**Re: The Northern Road Upgrade – Glenmore Park to Bringelly (SSI 7127 – Modification 1)
– Notice of Exhibition**

Council welcomes the opportunity to provide comments on the above modification application.

Council has reviewed the application and supporting documents and raises no objection to the proposed modification to replace the approved twin bridges over Adams Road within an at-grade signalised intersection, including changes to the horizontal and vertical road alignments.

Figure 1-1 | Overview of proposed changes to Stage 6 of the project

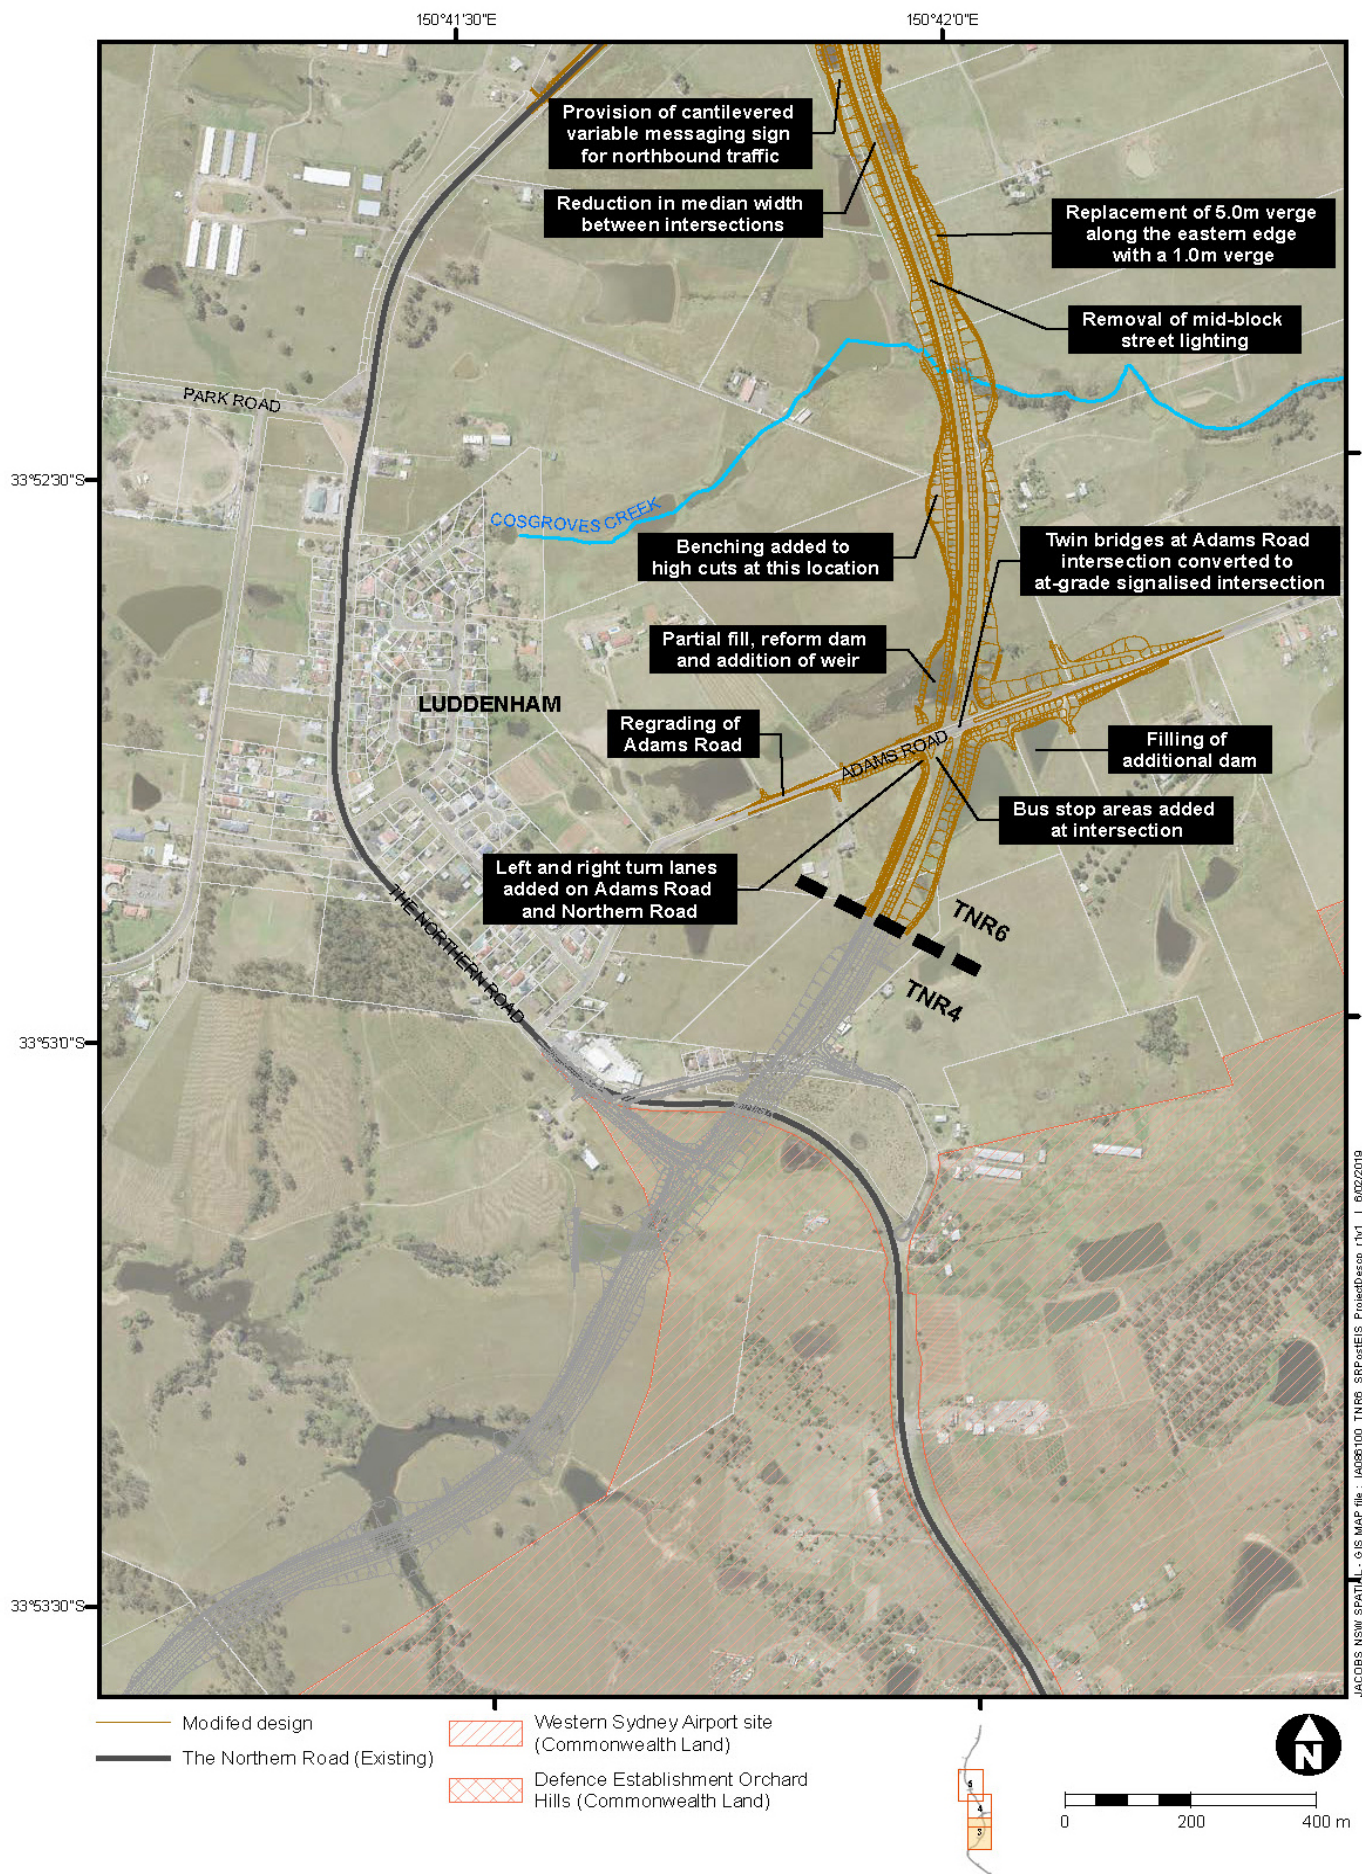
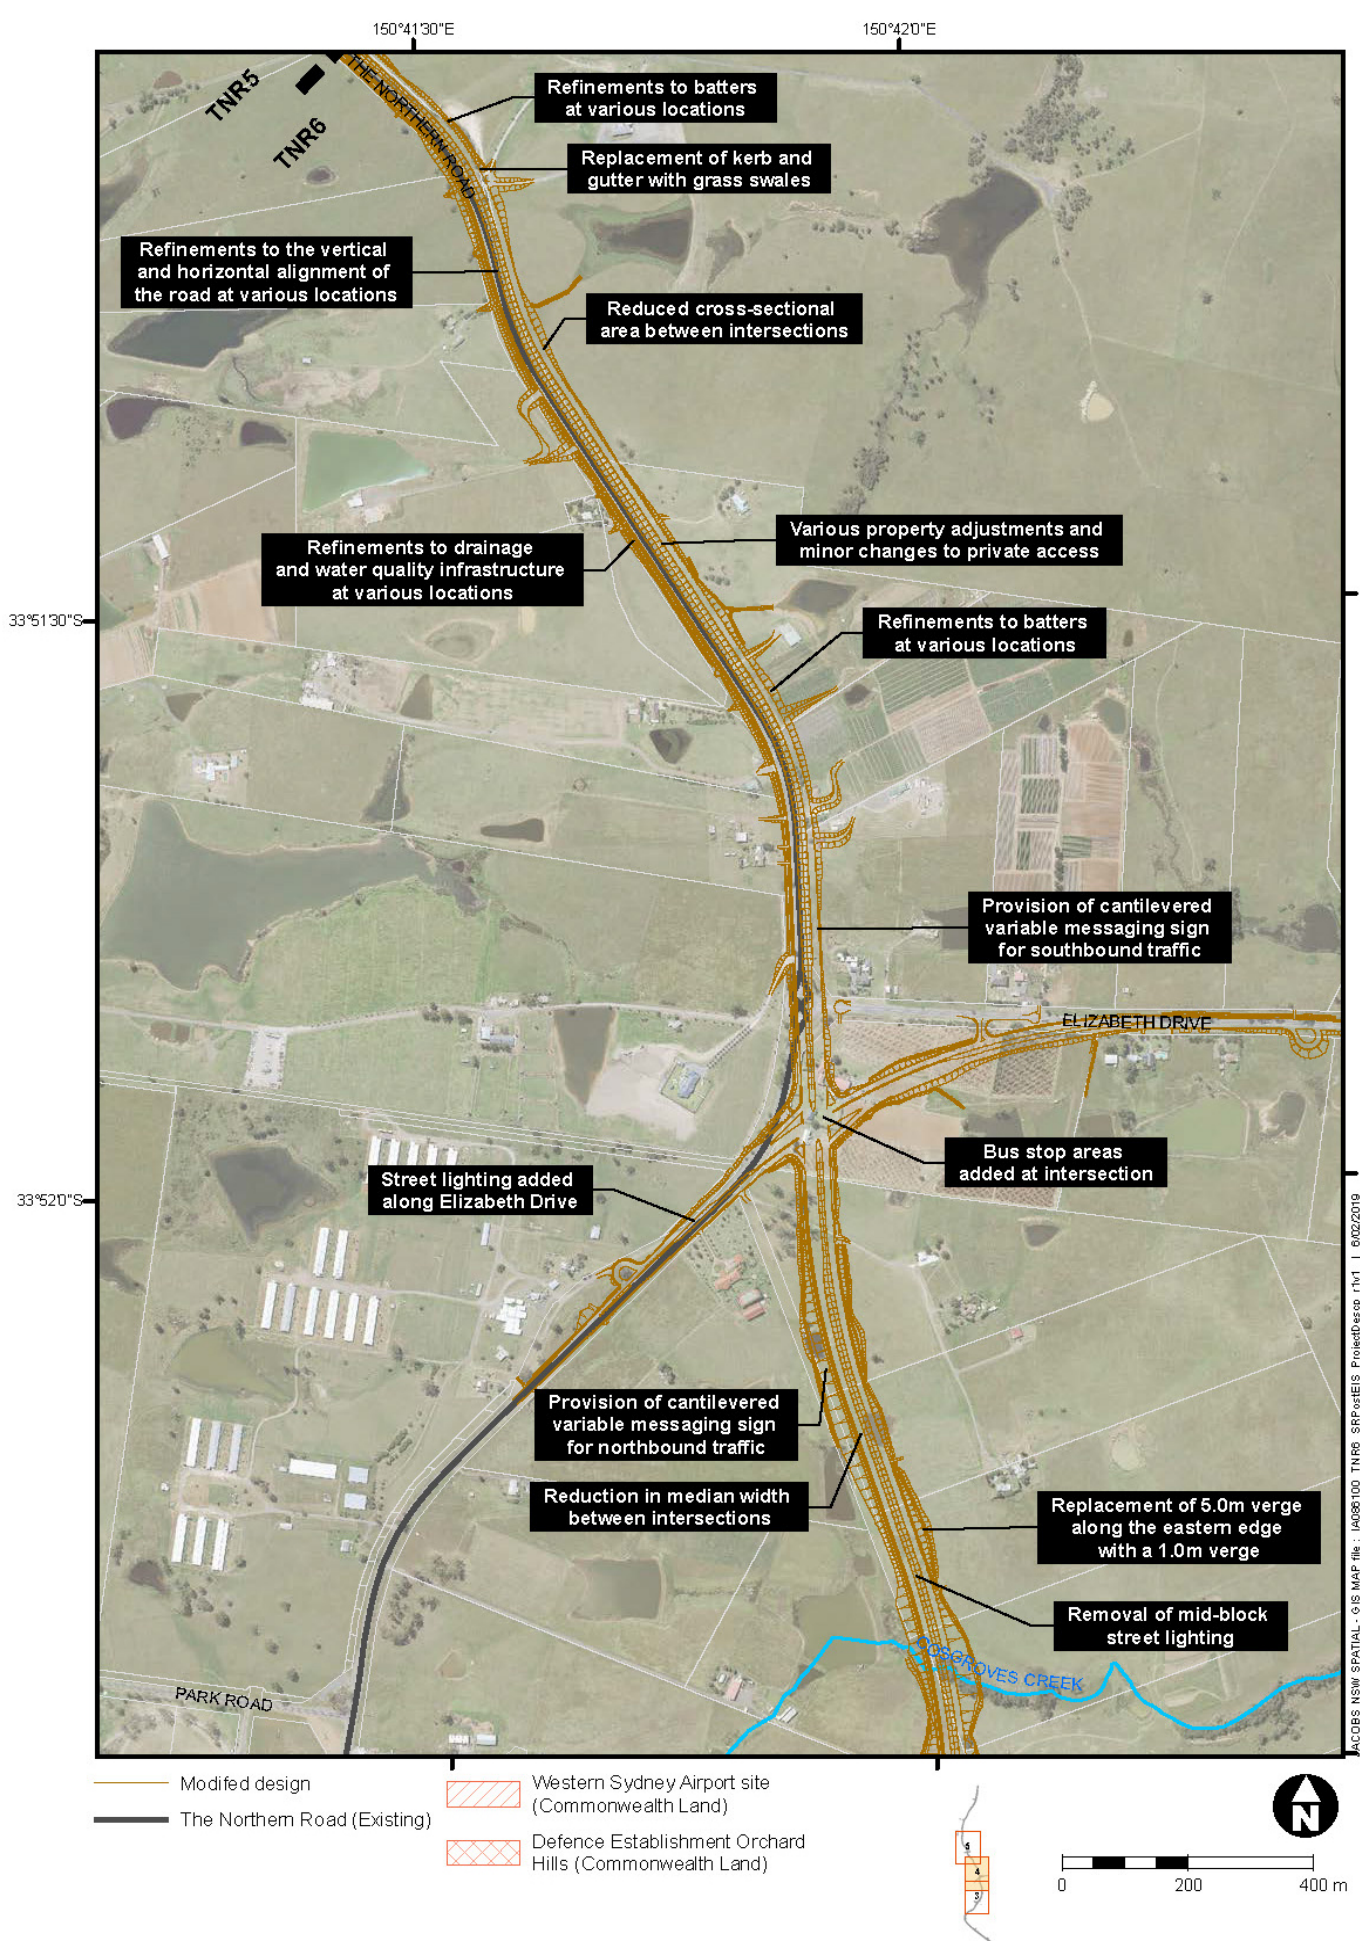
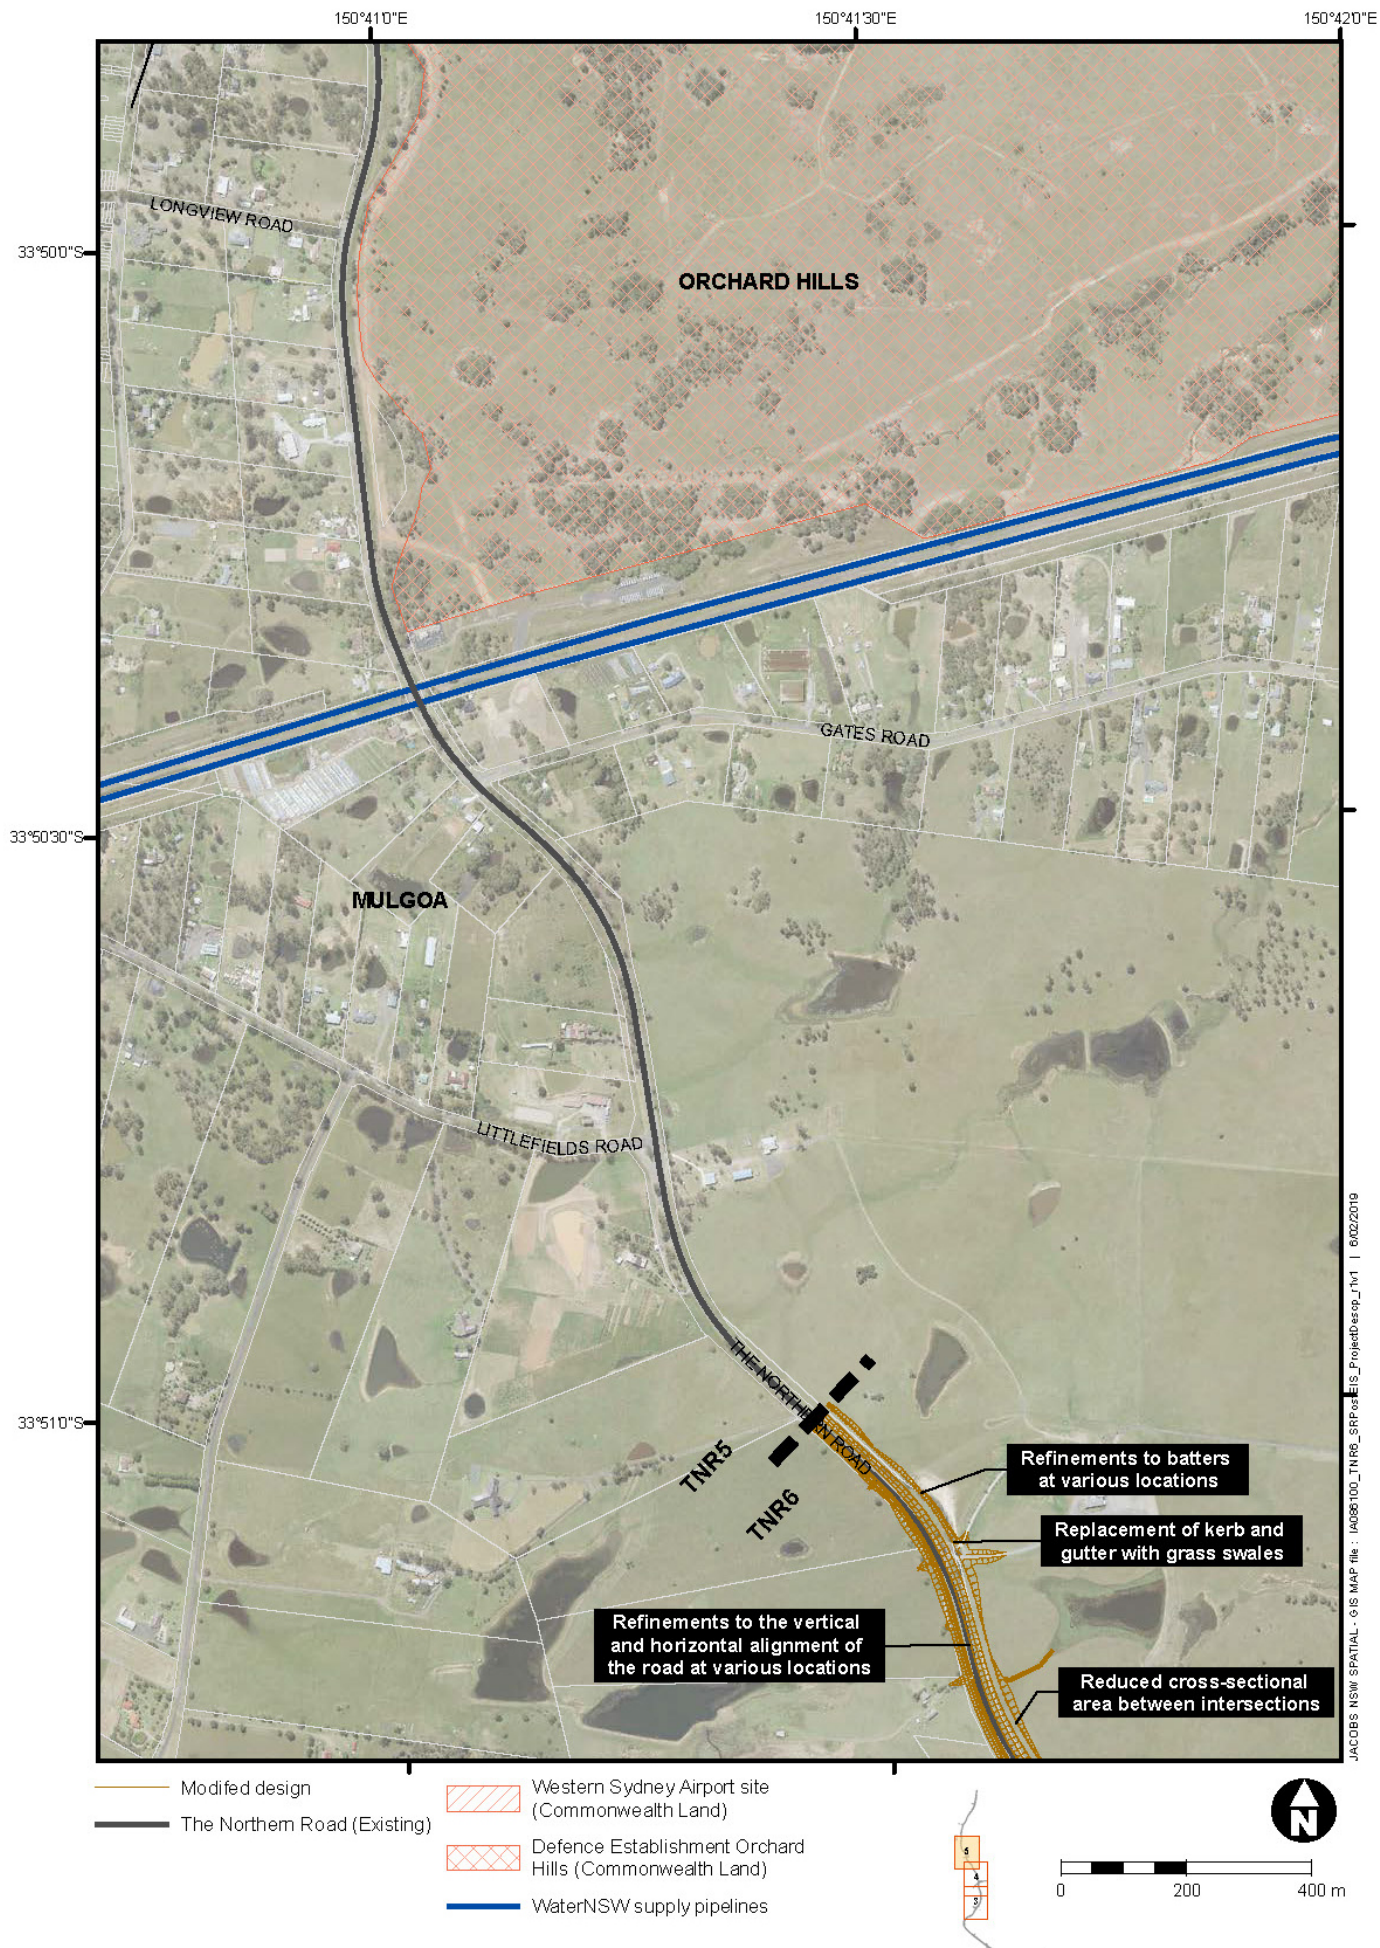
However, Council is concerned that the modification requires significant earthworks along Adams Road at the intersection.

Council requests that the Roads and Maritime Services (RMS) enter into an agreement for the extent and responsibility of maintenance works along Adams Road. This can be included as part of Council's previous request for an agreement for the maintenance of The Northern Road section through Luddenham Village which will be reclassified as a local road and handed over to Council.
